Attachment 2

SSD-76555711 – 3-5 Help Street, Chatswood

Recommended affordable housing, contributions, engineering and landscaping conditions

Project No. 301351072	Scale 1:200
Revision F	Drawing No. CI-060-101

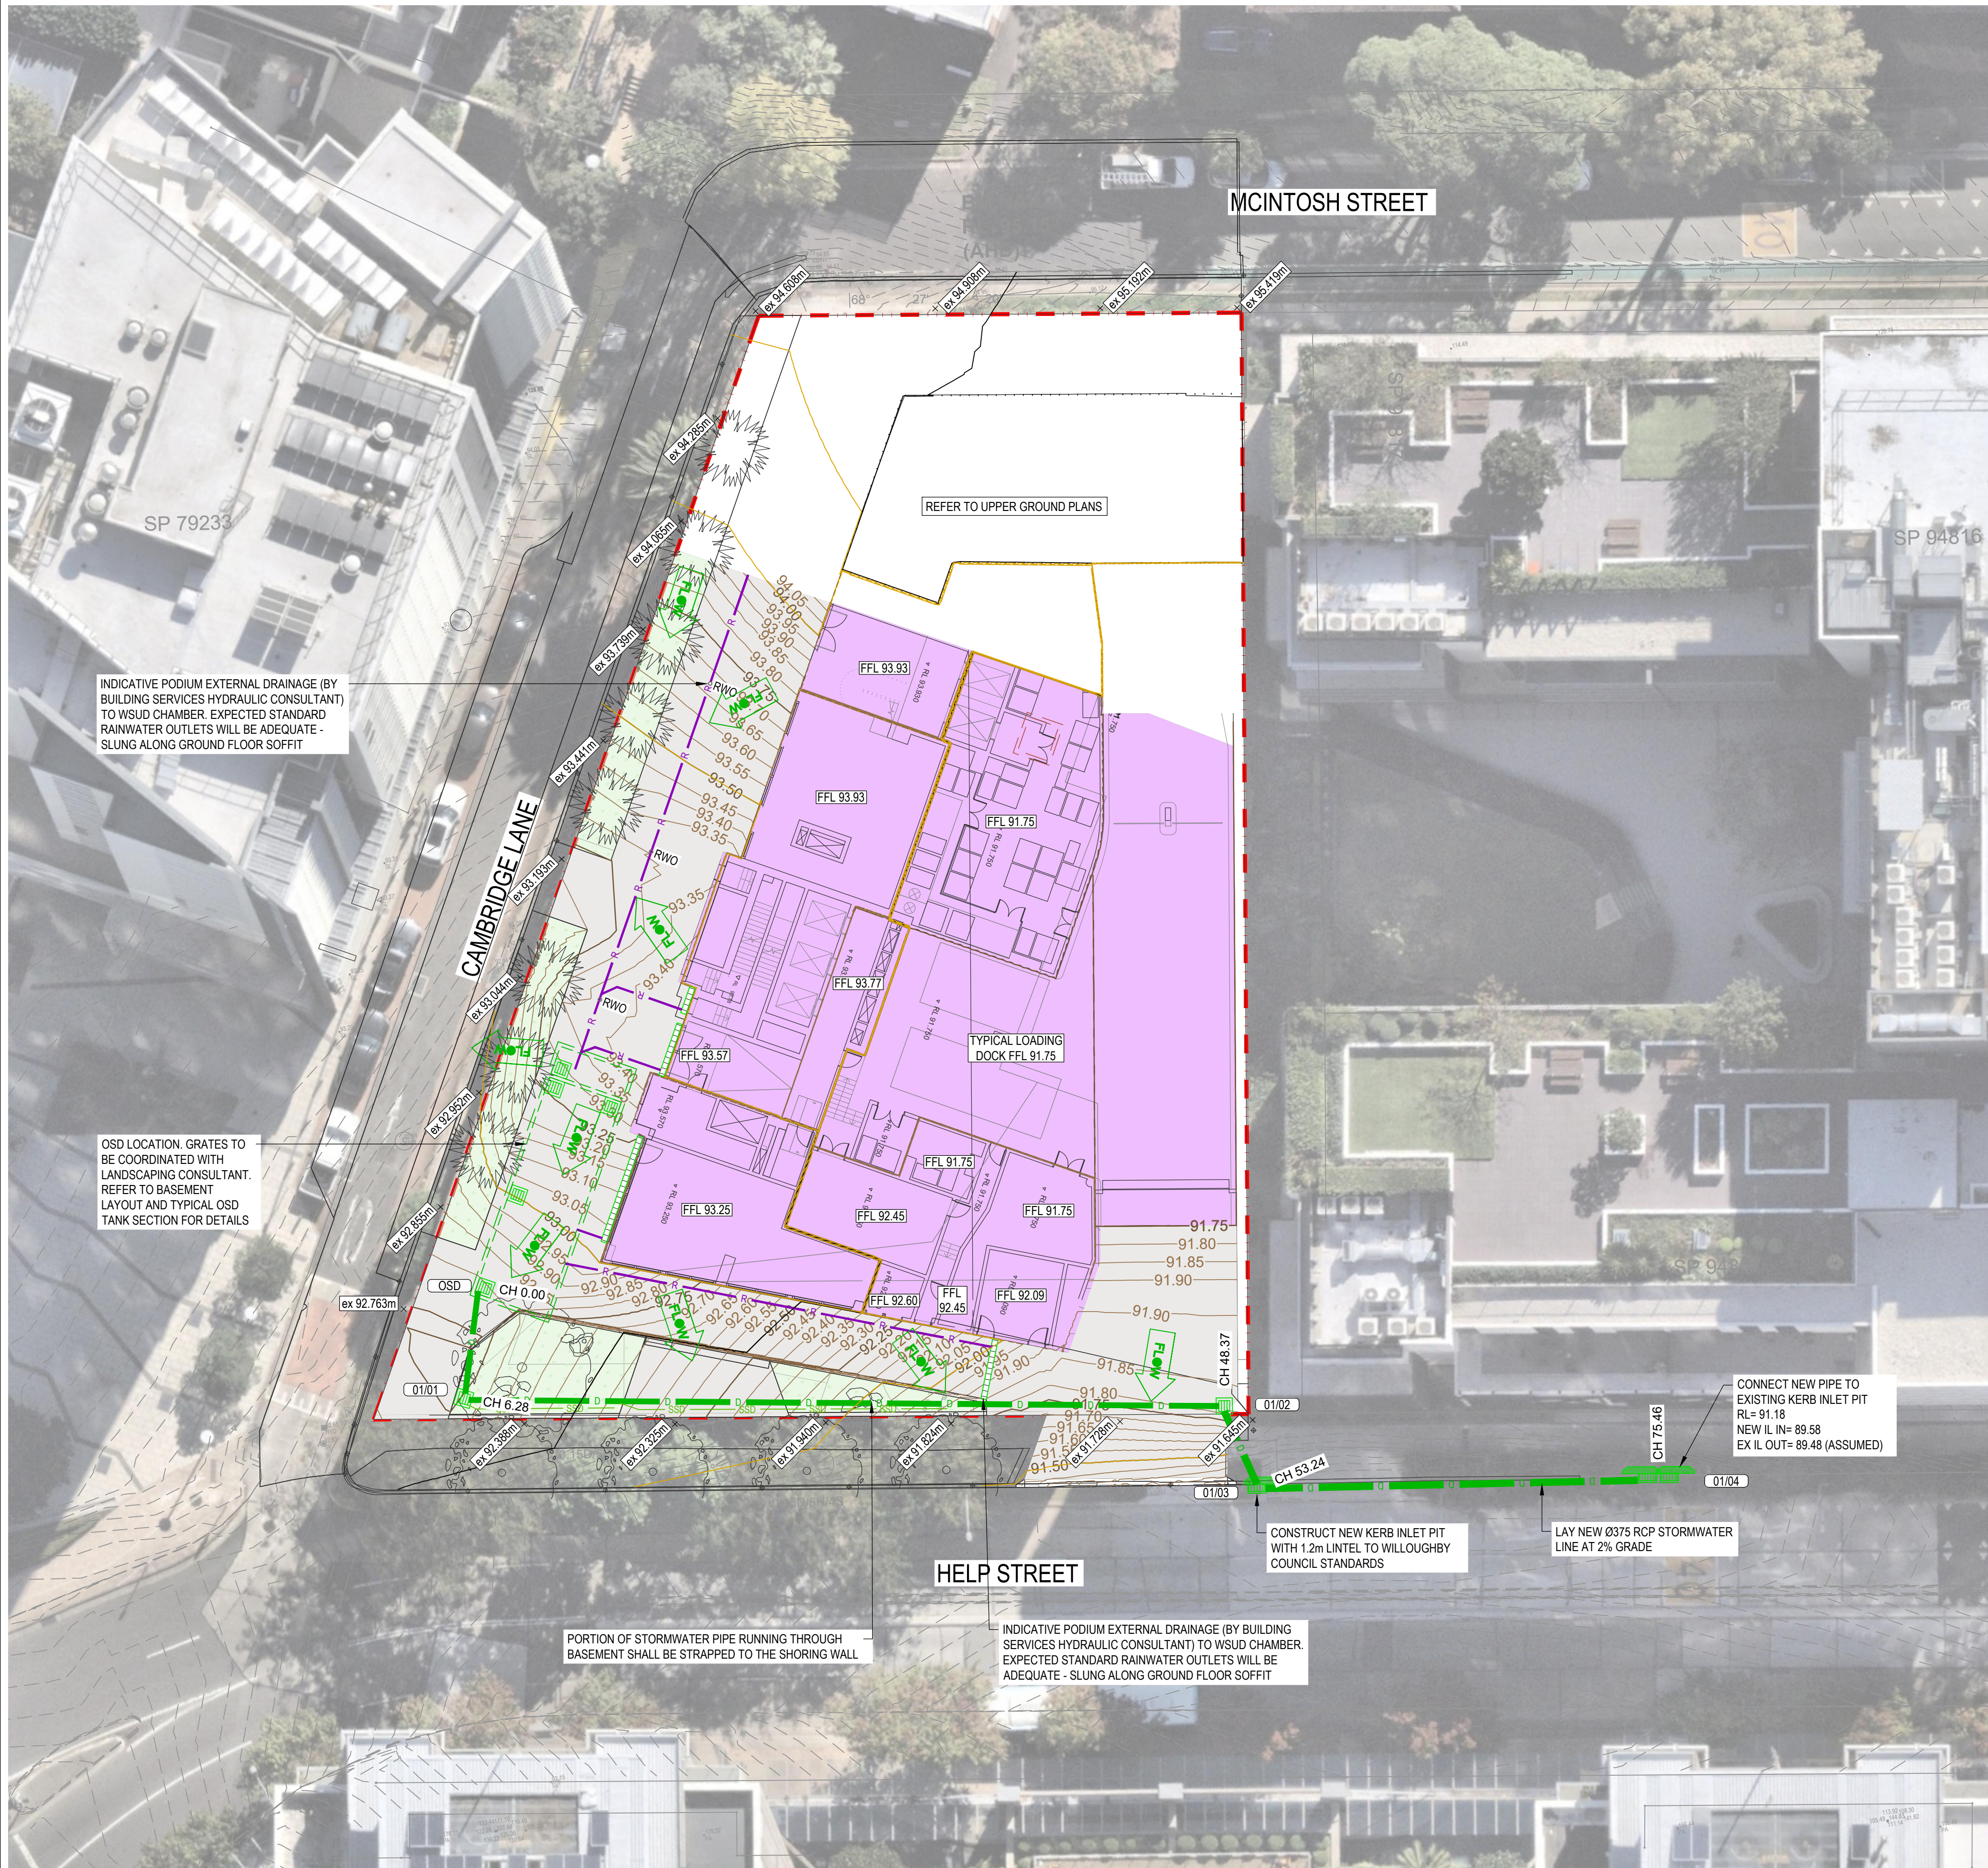
Detailed stormwater management plans prepared by a suitably qualified and experienced civil engineer, which include a OSD system and water quality management system for the site. The plans are to be generally in accordance with Stantec drawings CI-060-101/F, CI-060-201/I, CI-060-301/F, CI-500-001/D, CI-522-001/F, CI-526-001/E and CI-526-002/G, amended to include the following items:

- (a)
 - Details to confirm that the permitted site discharge (PSD) required by Technical Standard 1 is achieved from the site, which includes allowance for flows that bypass the OSD system. The PSD is to be achieved for the 1%AEP storm event. If the bypass area exceeds 5% of the total site area, then a Drains analysis is to be undertaken and a summary provided on the plans to confirm the OSD volume required and the PSD achieved. For calculation purposes, any areas located over the basement must be considered as impervious areas. The maximum PSD from the site is to be 39L/s in the 1%AEP event, based on a total site area of 2,320m².

- A hydraulic grade line analysis for the 1%AEP storm event, extending from the OSD tank to the connection point to the Council drainage system in Help Street, with the adopted downstream water level to be the top of kerb level at the Council pit. The analysis is to confirm that the OSD outlet is above the downstream water level during the 1%AEP storm, with the tank having a minimum invert level of RL91.45m.

- Details to confirm that 300mm freeboard is achieved between the overflow from the OSD system and the adjacent floor level. The overflow from the OSD tank, and the level used to determine the freeboard, must be to ground via the access grate in the roof of the tank or through the side wall, discharging to ground and not to a pipe

- Details to confirm that the pipe system draining to the OSD tank is able to convey the flow from the 1%AEP storm event or that an overland flows in excess of the pipe's capacity drain to the OSD tank in all storms up to and including the 1%AEP storm.

ON-SITE DETENTION TANK - PLAN

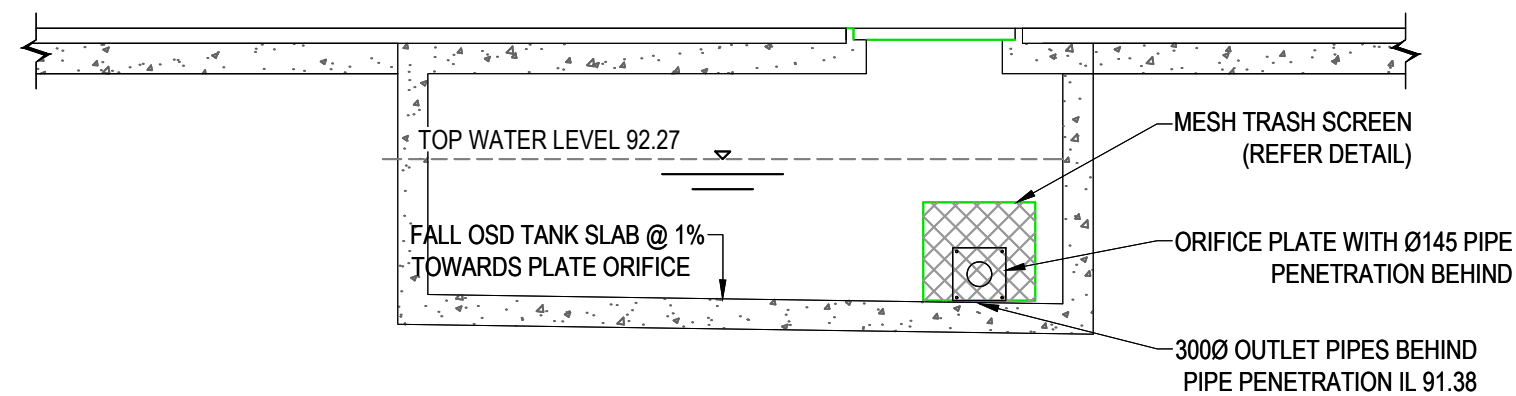
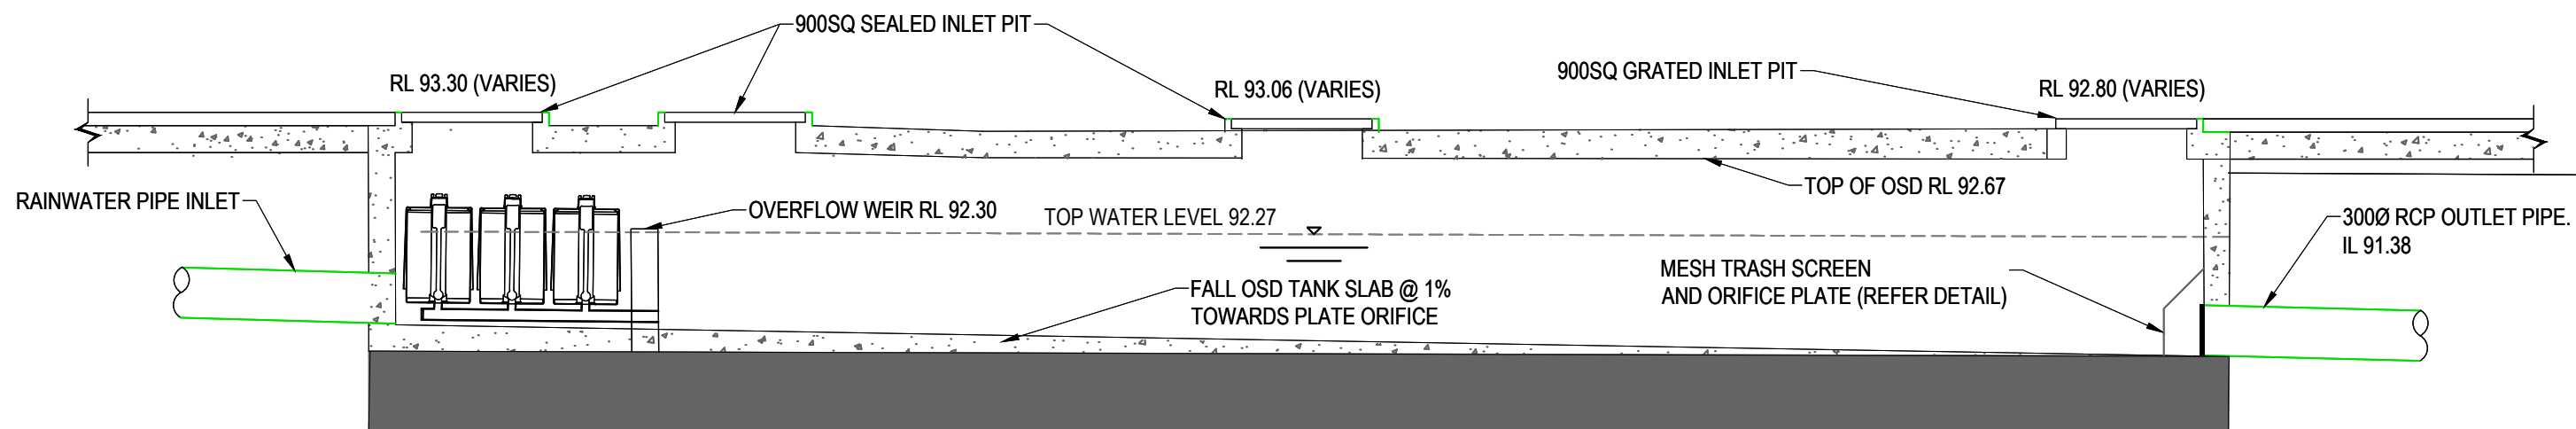
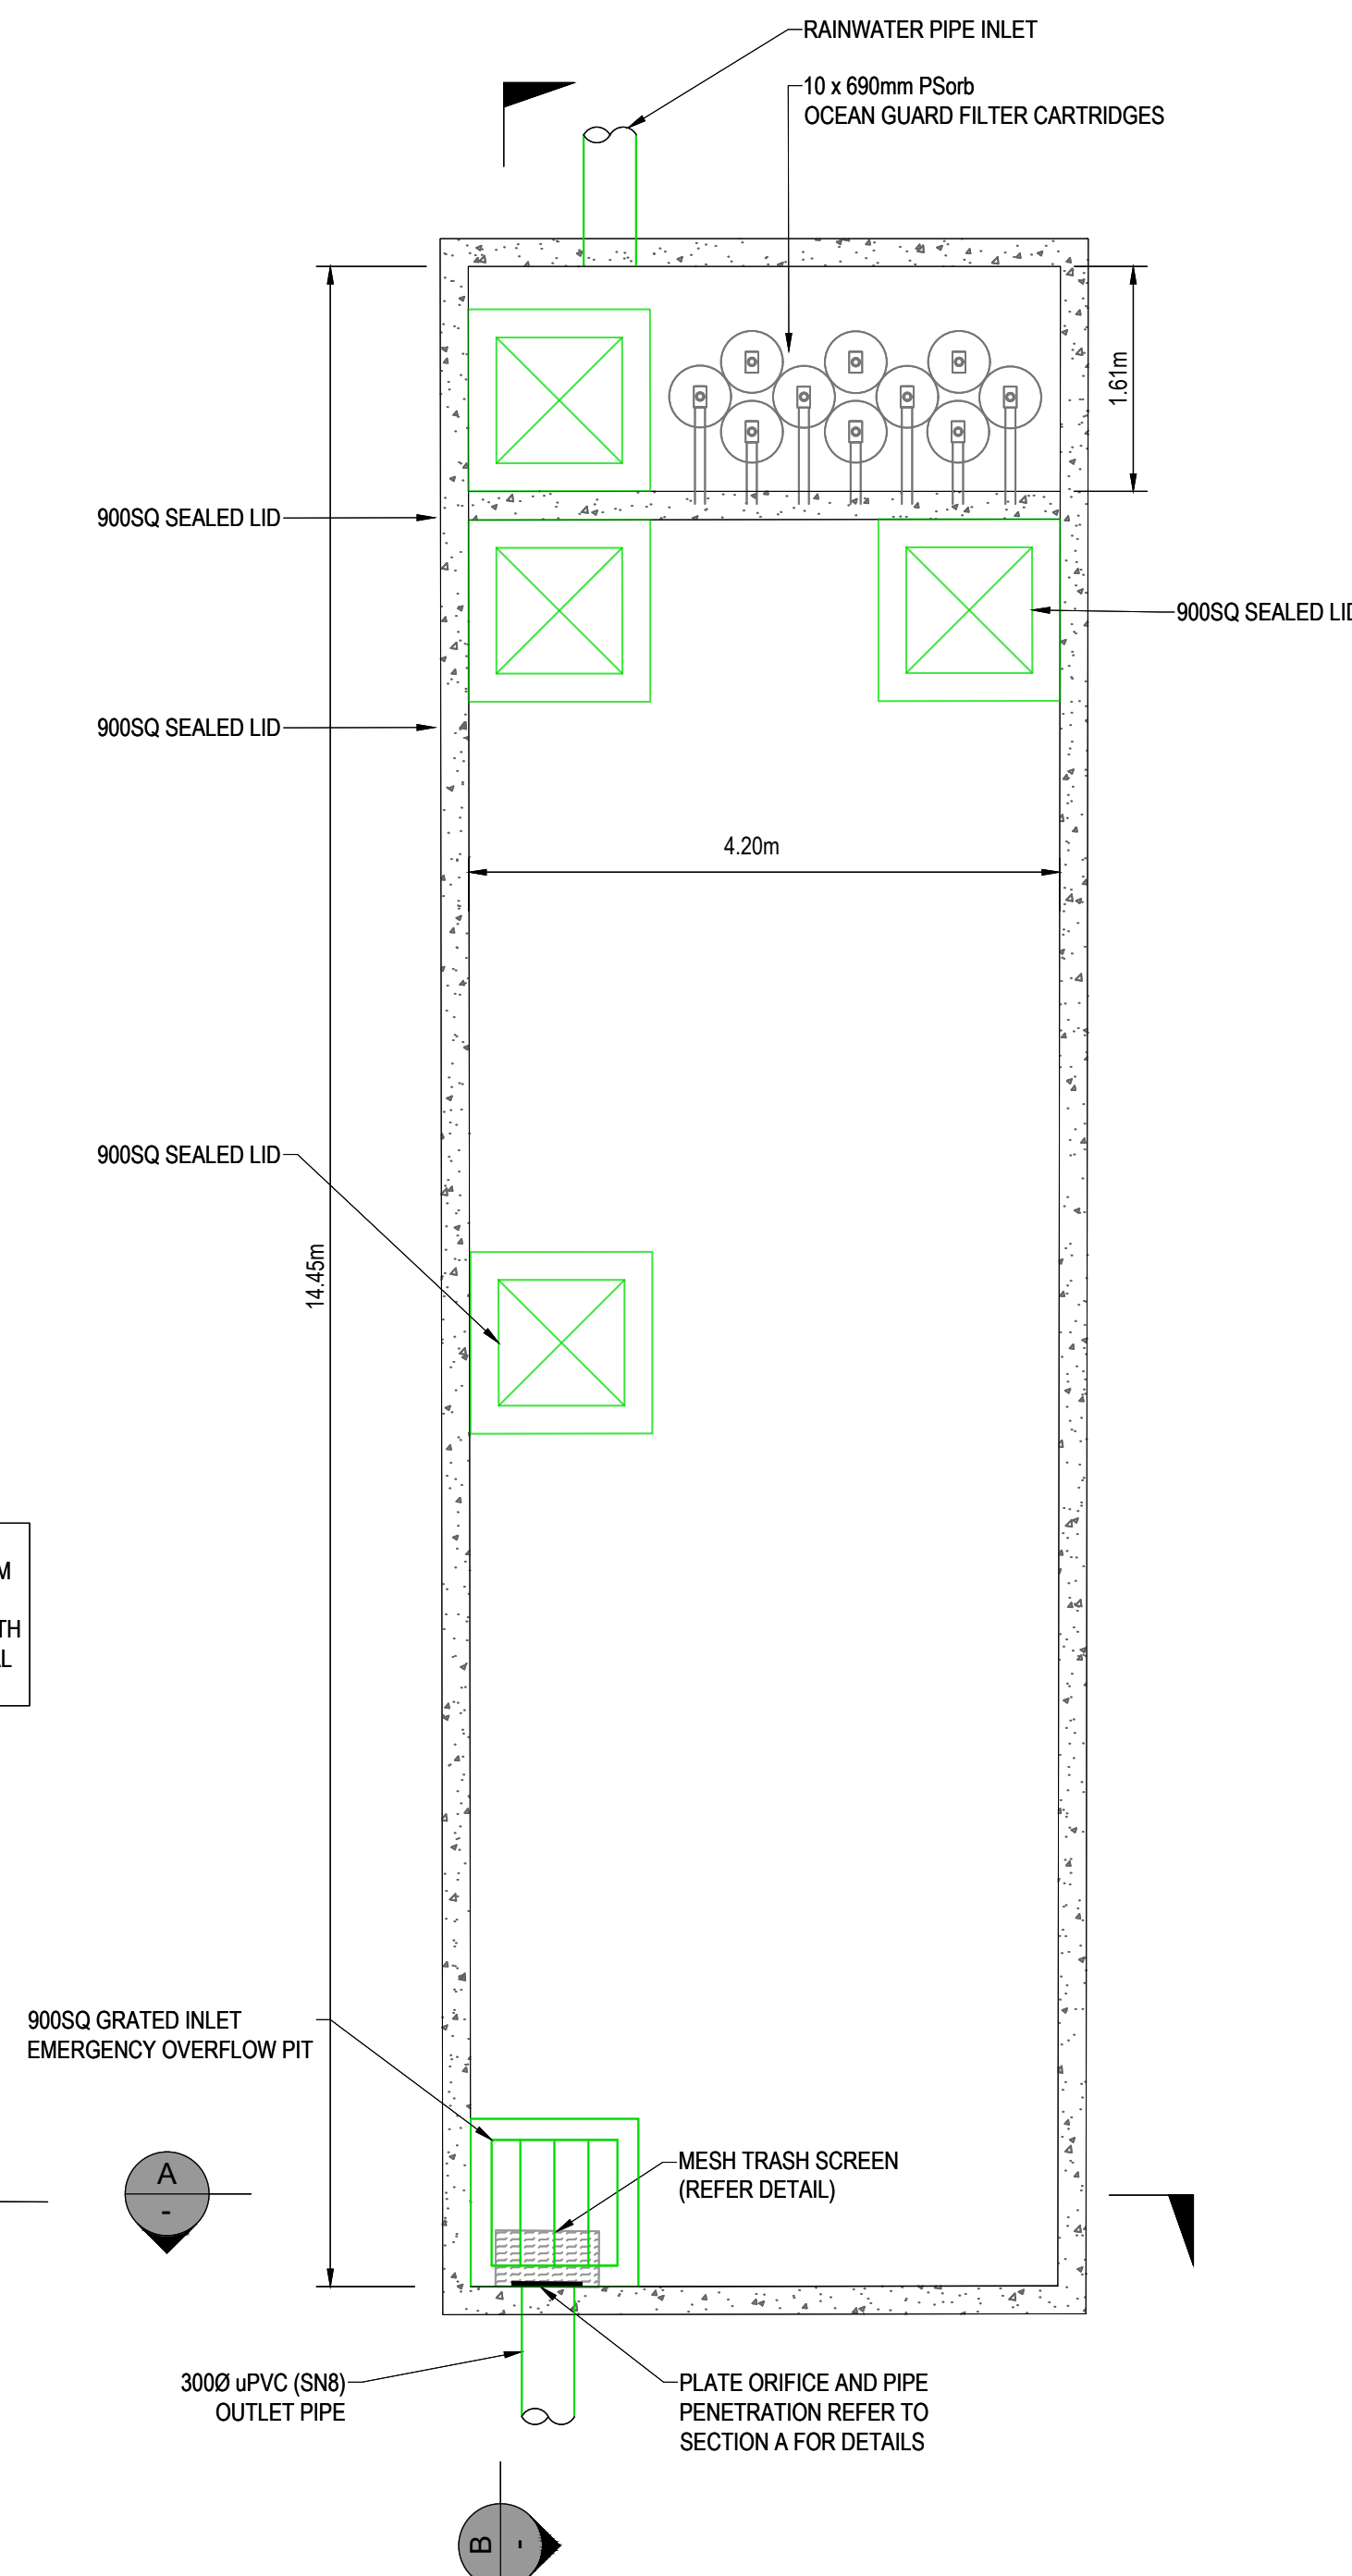
Calculations are to be submitted as required to demonstrate that the OSD system complies with the requirements of Technical Standard 1, including that the system has been designed for the 1%AEP storm event. The system shall be designed for the entire site area, with a minimum OSD volume of 82m³ and a PSD for the 1%AEP of 39L/s (based on a site area of 2,320m²).
